Comments for Planning Application DM/21/00002/LB

Address: Rose Stile Cottage Sennings Lane Romaldkirk Barnard Castle DL12 9ED

Proposal: Listed Building application for installation of CCTV equipment, 2no raised deck areas to front garden and erection of detached exercise room to rear garden (retrospective)

ROSE STILE COTTAGE
 ROMALDKIRK
 PROPOSED EXERCISE ROOM
 SCALE 1:50 AUGUST 2020

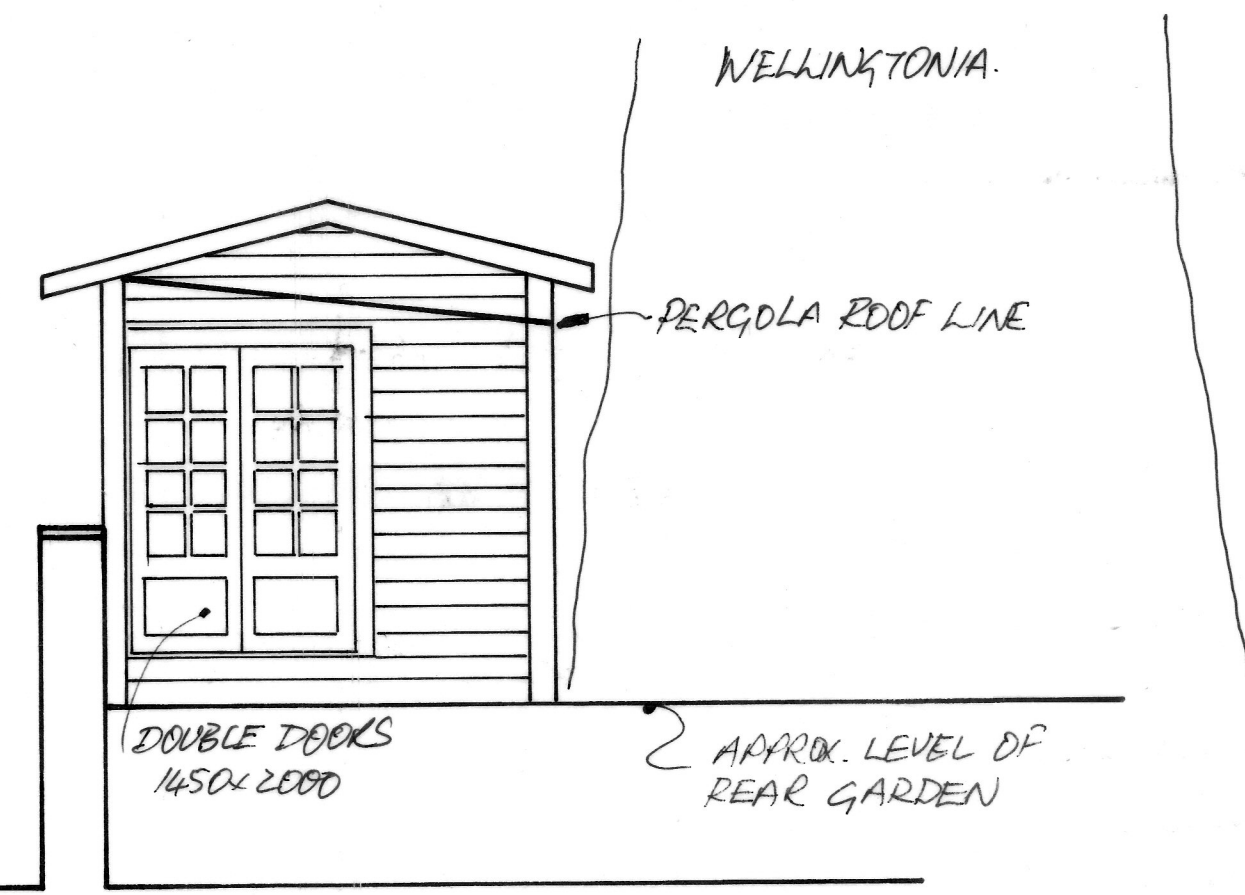
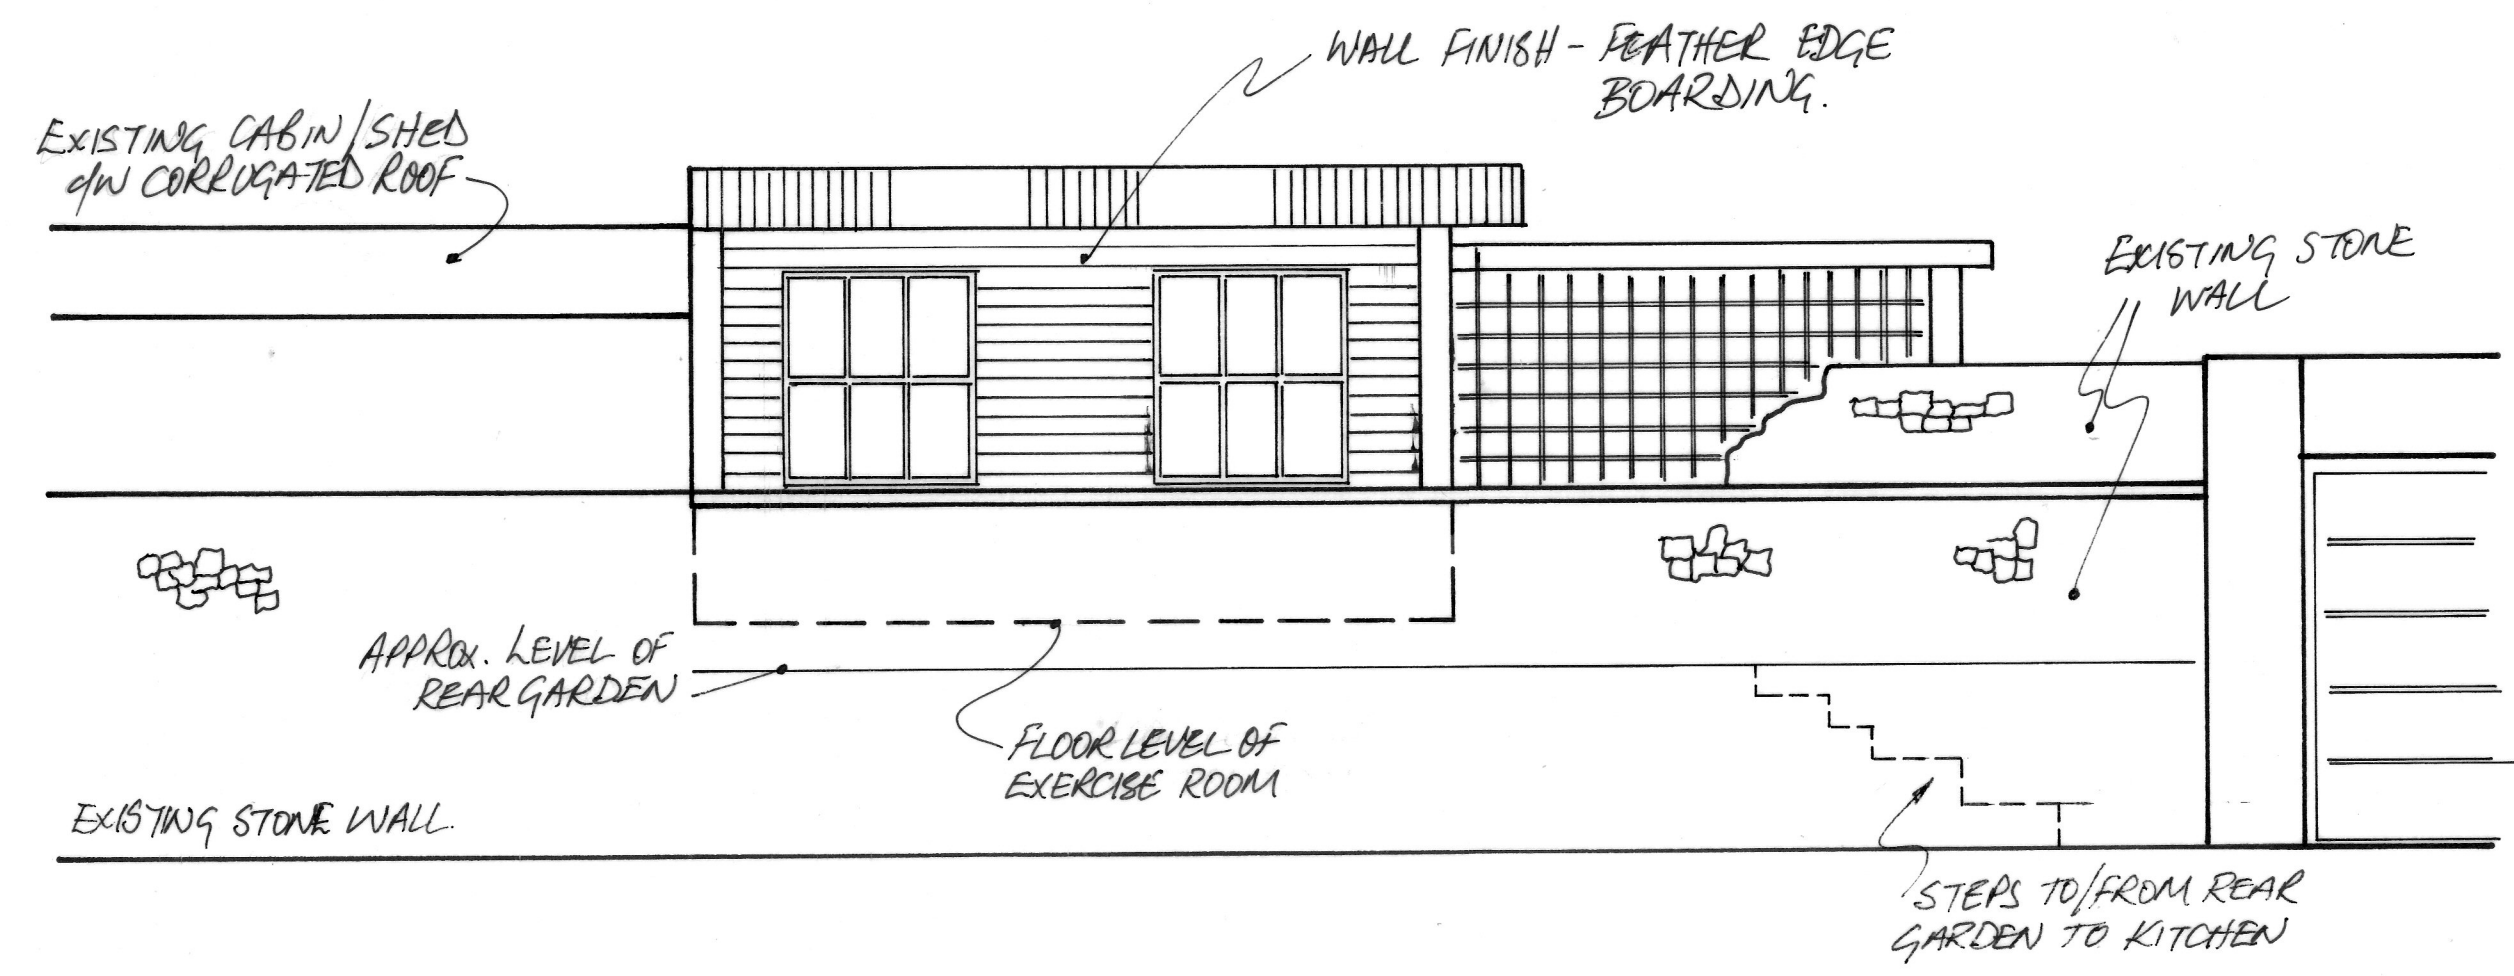
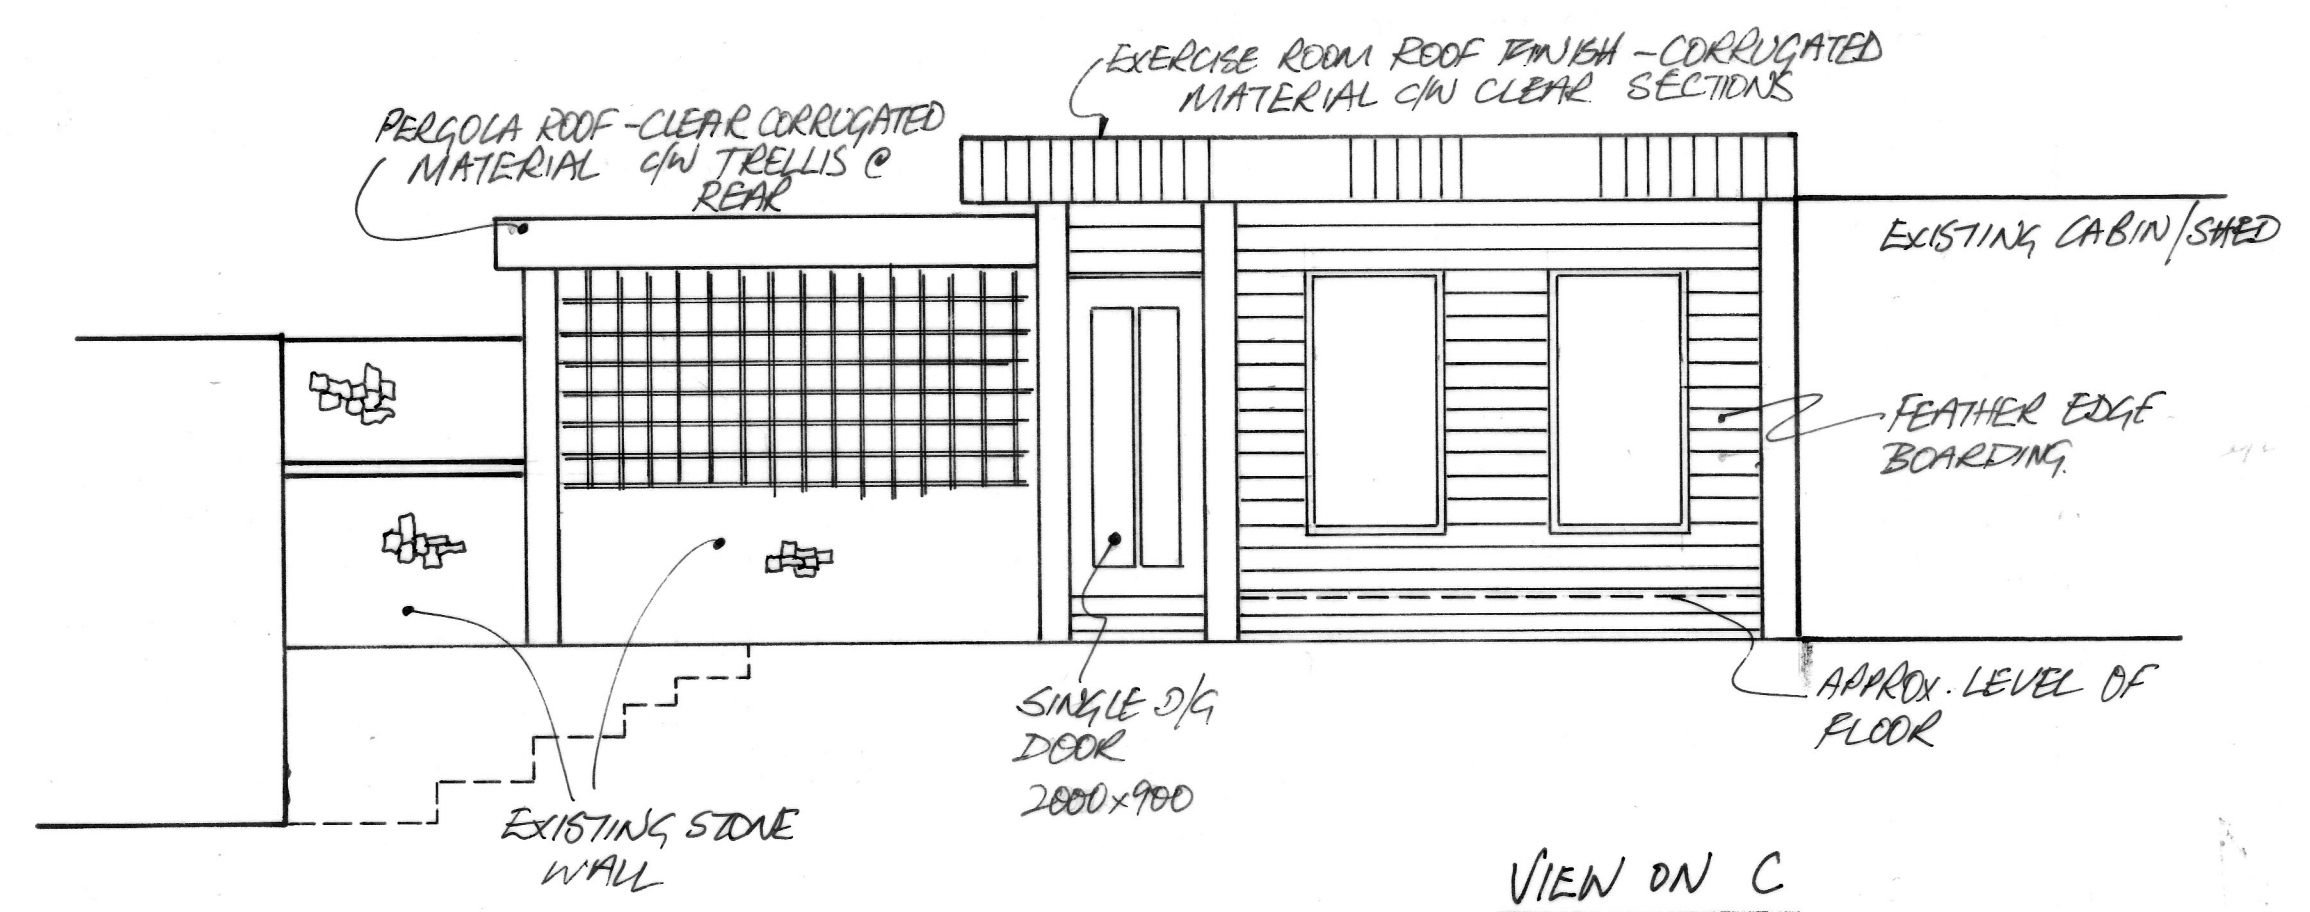
Regarding the detail of the proposals, the size of the windows in the Sennings Lane side of the building are disproportionately large for the size of the structure. The selection of transparent plastic sheeting for the pergola roof, combined with corrugated metal for the Exercise Room, are not in keeping with the house roofing materials and those commonly found in the village. Together with the featherboard siding they are materials incompatible with the heritage structures of the house and village. The past use of some of these materials on the site should not be justification for their extended application.

The inclusion of a set of double doors and a single door looks excessive relative to the size of the building. Access to the garden and Exercise Room is only through the house or the adjacent hut, all with single doors.

The large area of glazing and skylights for ventilation is not compatible with the problematic low-level chimney that will be only slightly above window level and approximately 4.5m from the doors. The Wellingtonia already significantly disrupts the chimneys' function and results in horizontal and

The proximity of the shed wall to the perimeter wall will make maintenance difficult to impossible for part of the façade and the wall.

We are anticipating the new building will be connected to the existing shed for access through an expanded existing window opening. The submitted drawings do not address this. This would add a third door to the small exercise space.

The proposed new building roof is drawn to overhang the perimeter wall, presumably with the same intent. Access to the existing combination sewer system will be difficult due to the house foot print blocking access to the front yard drain location.
